State Significant Development Application (SSD 8816)

Precinct 4A, Royal North Shore Hospital
Development
St Leonards Health Organisations Relocation
(SHOR)

Submitted to Department of Planning &
Environment
On behalf of NSW Health Infrastructure

11 May 2018 | 16611

Figure 5: Recommended Acoustic Treatment to Roof Plant Compounds

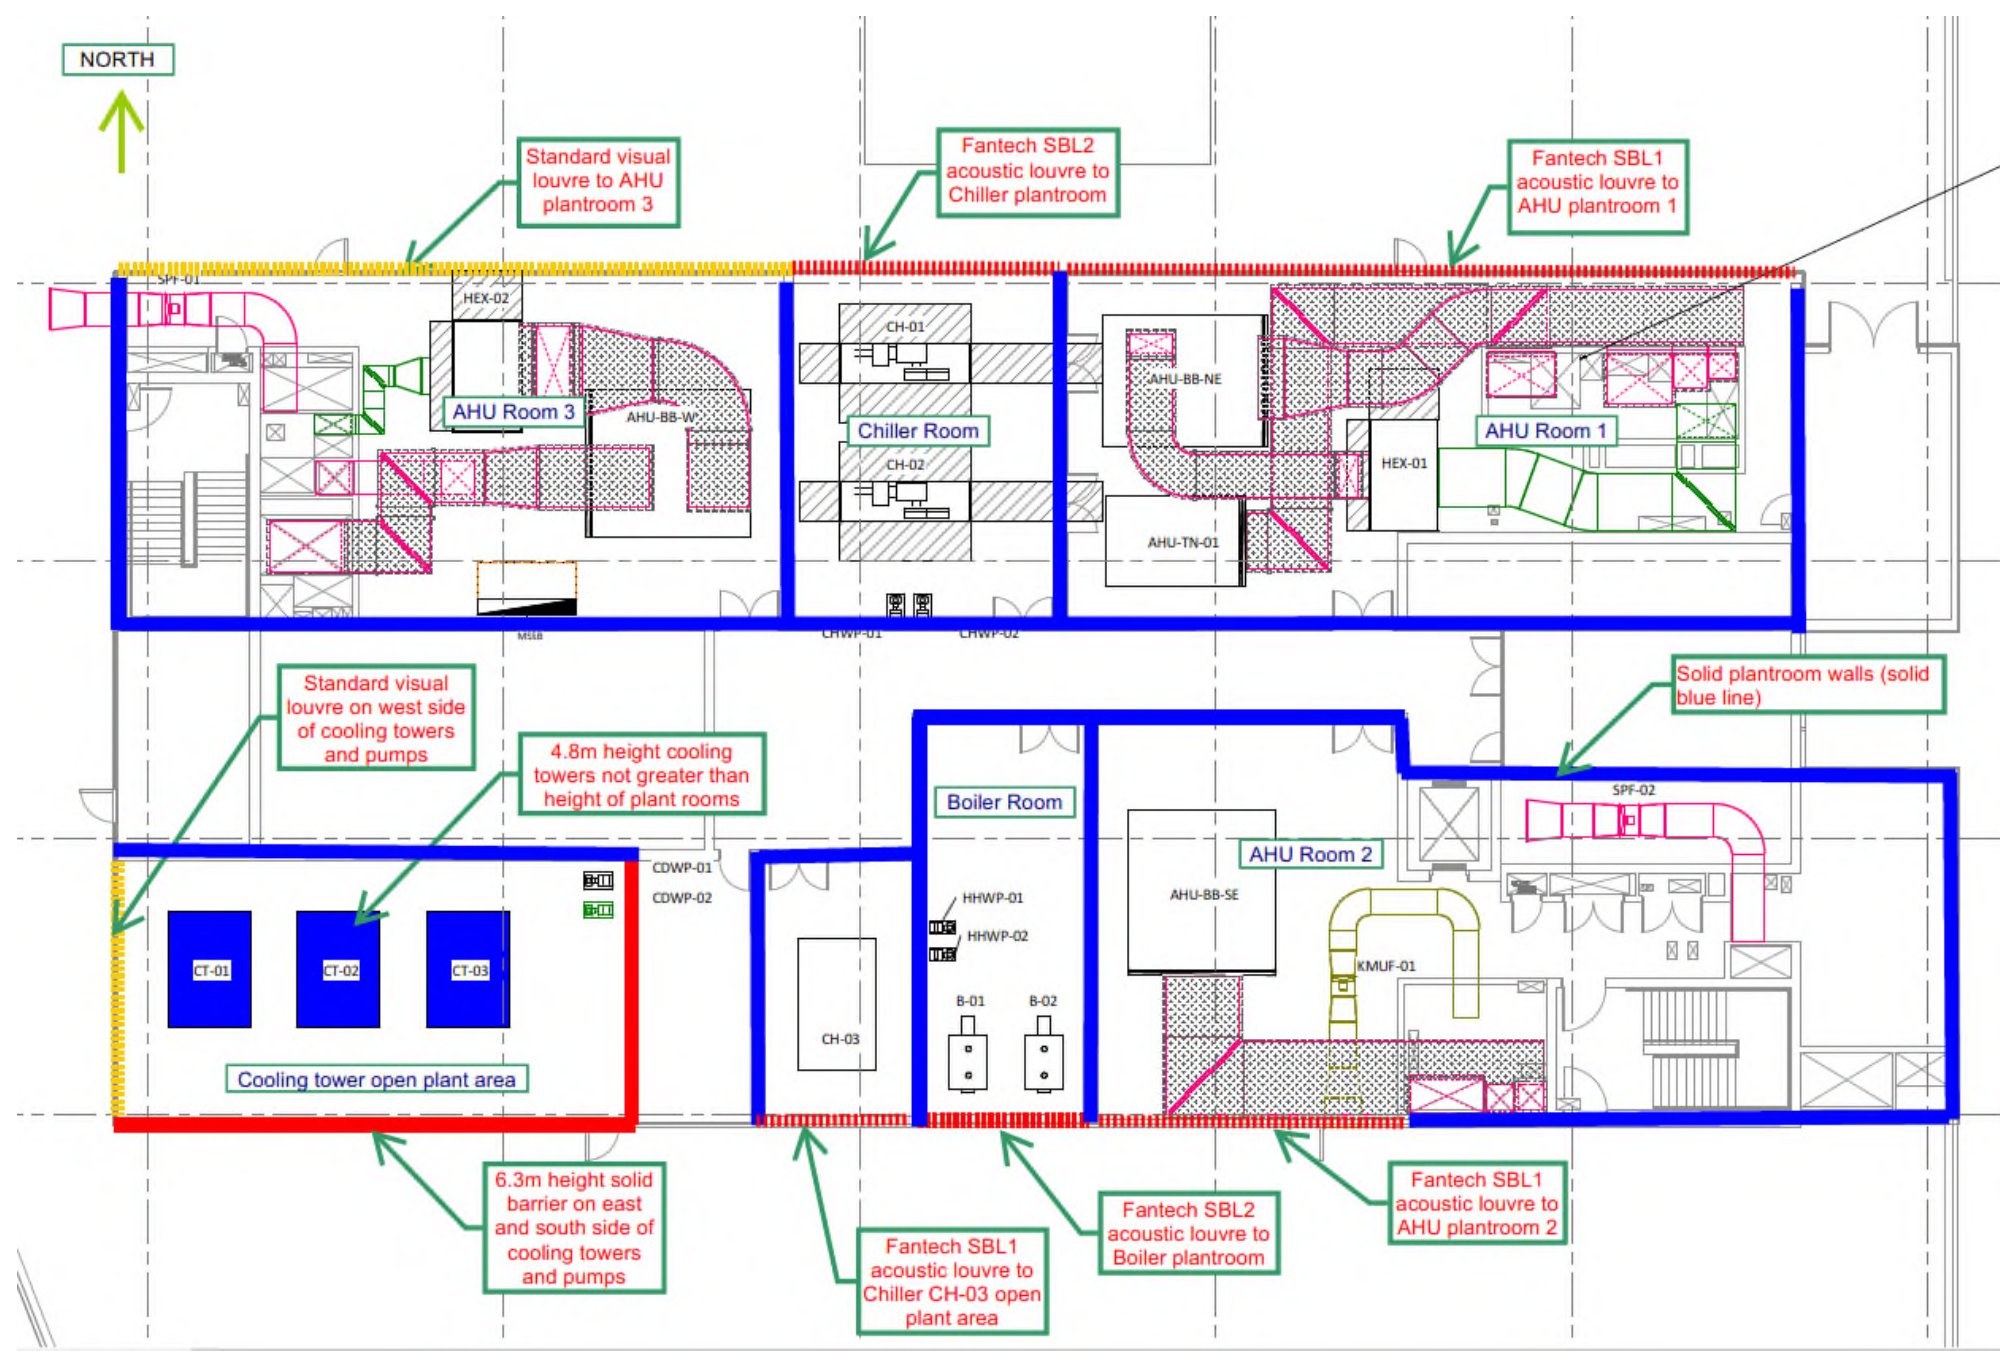
- *Details of the incorporation of the recommended acoustic treatment measures into the southern and eastern sides of the rooftop plant area must be provided, noting the submitted Operational Noise and Vibration Report recommends the installation of a 6.3 m tall acoustic screen, which if installed would result in a building exceeding the maximum permitted height.*

Additional background noise monitoring has been commissioned by NSW Health Infrastructure to be undertaken in accordance with the *Noise Policy for Industry*. Renzo Tonin Acoustic Consultants will update the Construction Noise Management Plan and Operational Noise and Vibration Report upon completion of the additional noise monitoring and it will be submitted to the Department of Planning and Environment under a separate cover.
